Development Facilitation Team (DFT) – Review Comments

Project No: PR-2022-006568

Legal Description: LOTS 4 AND 5, BLOCK 16 TRACT 3, NORTH ALBUQUERQUE ACRES

Application For: SD-2023-00147-PRELIMINARY PLAT (DHO)

PRELIMINARY PLAT
 VALENTINO ESTATES
 (A REPLAT OF LOTS 4 & 5,
 BLOCK 16, TRACT 3, UNIT 3,
 NORTH ALBUQUERQUE ACRES)
 WITHIN THE
 ELENA GALLEGOS GRANT
 PROJECTED SECTION 17
 TOWNSHIP 11 NORTH, RANGE 4 EAST, N.M.P.M.
 CITY OF ALBUQUERQUE,
 BERNALILLO COUNTY, NEW MEXICO
 JUNE, 2023

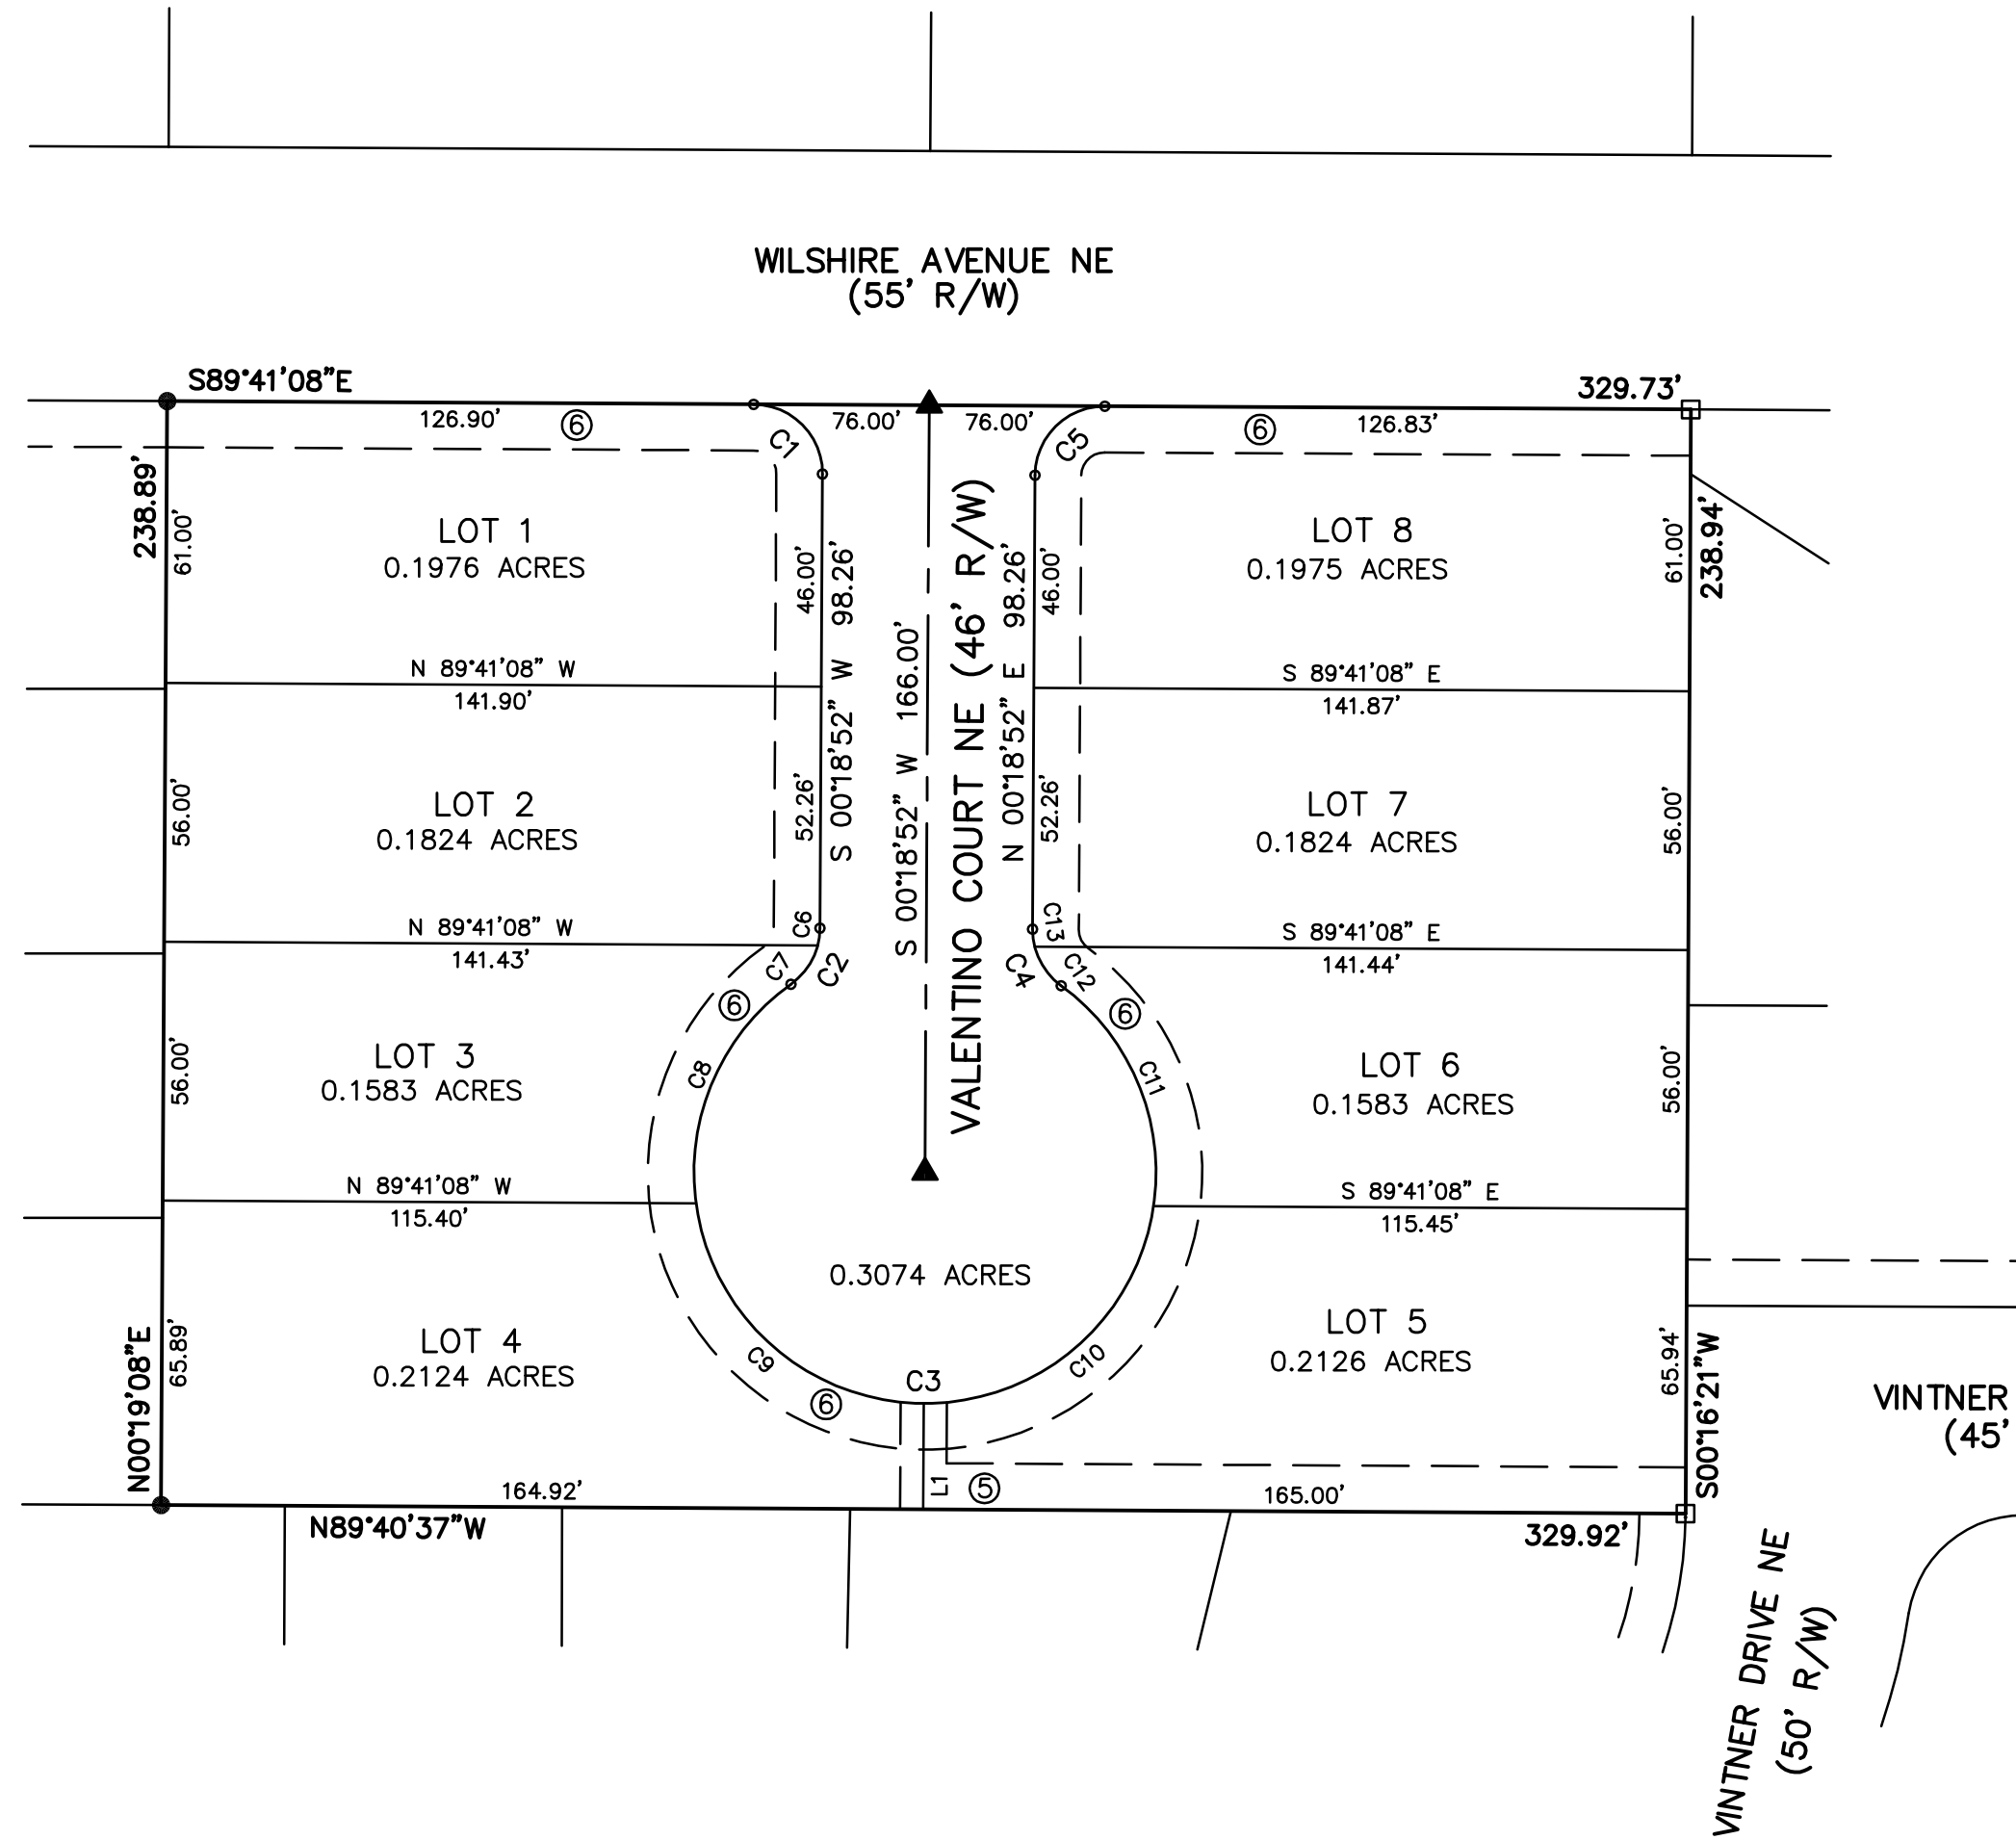
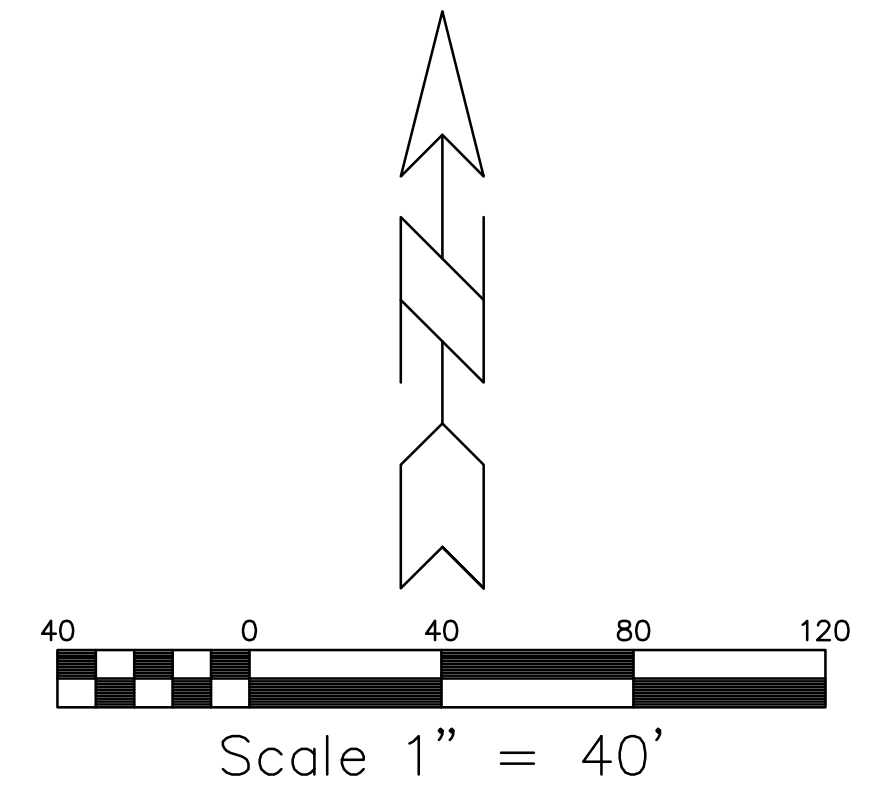
1. Please meet minimum standards for the diameter of the cul-de-sac per the DPM. You are showing 100' radius but the DPM shows 96' for the roadway alone, where right-of-way must be given for sidewalk and landscape buffer also.

1. Property is located in an R-1C zone, and must meet all dimensional standards of IDO 5-1(C), Table 5-1-1.
2. Minimum lot size in R-1C is 7000 square feet, or 0.1606 acre. Lot 3 & Lot 6 are 0.1583 acre, 6895 sq. ft..
Must increase size, seek deviation from DHO, or seek Variance from ZHE prior to platting.
3. CE has no further comments at this time.

- Planning staff defers to the **Water Utility Authority** regarding keyed note #6: public utility easement on proposed Preliminary Plat.
- Subject property does not currently have vehicular access. Planning staff defers to Transportation staff on vehicular site access, improved alleyways, vacation of right-of-way or easement (**DPM Part 2-9(E) Vacation of Right-Of-Way Of Easement**), Certification of approval by the City Traffic Engineer (**DPM Park 5-3(K) Certifications**), Public Sidewalks (**DPM Section 7-4(E)(1)(i) Public Sidewalks General Provisions #2**). All new roadway construction shall include sidewalks and landscape/buffer zones installed on both sides of the street).
